Application by Port of Tilbury London Limited for an Order Granting Development Consent for a Proposed Port Terminal at the Former Tilbury Power Station ('Tilbury2')

The Examining Authority's First Written Questions and requests for information (FWQs)

Issued on 27 February 2018

Figure 7: PoTLL asset and tenant area breakdown

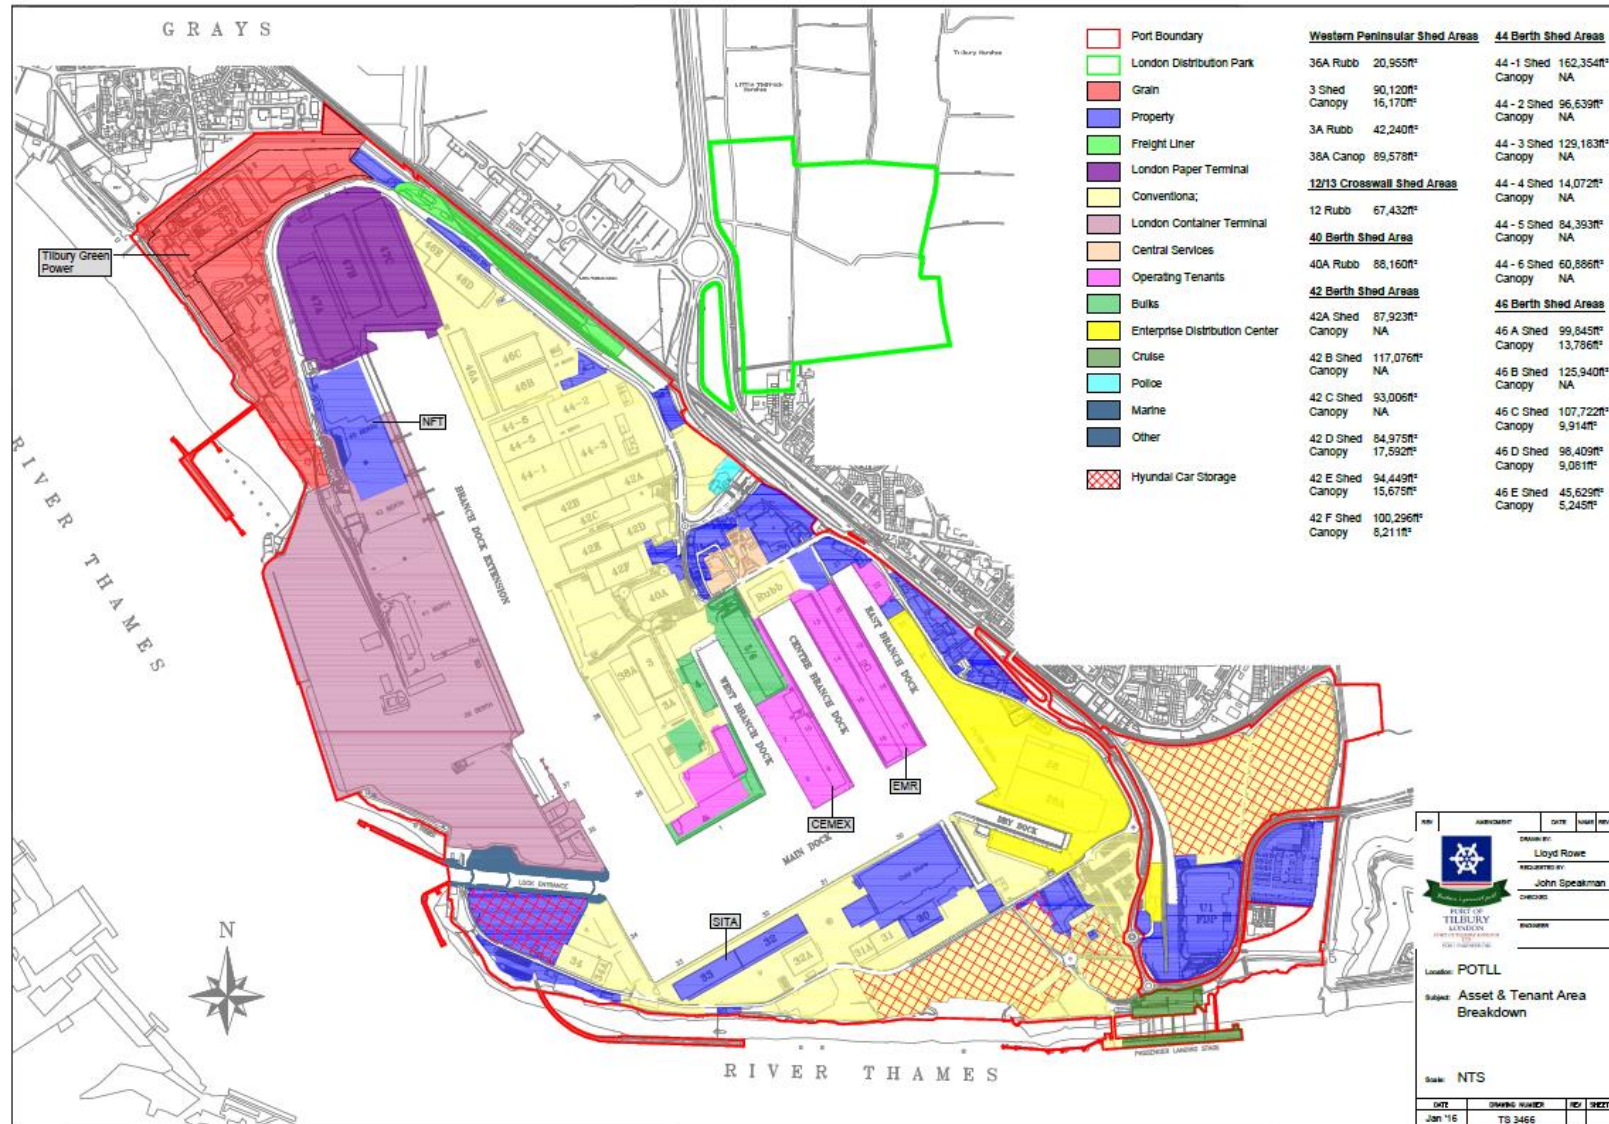
1.0.3	Applicant	Please could the Applicant provide a plan showing: <ul style="list-style-type: none"> a) all of the land under its control (that is land that is owned or occupied by the Port of Tilbury London Limited, or any of its parent or subsidiary companies) in and around Tilbury, including any industrial estates or parks, in the vicinity of Tilbury Docks; and b) the current usage and names of tenant/occupiers of the various areas within the land identified as under its control. Whilst Figure 7 in the Outline Business Case provides some of this information, it is not comprehensive.
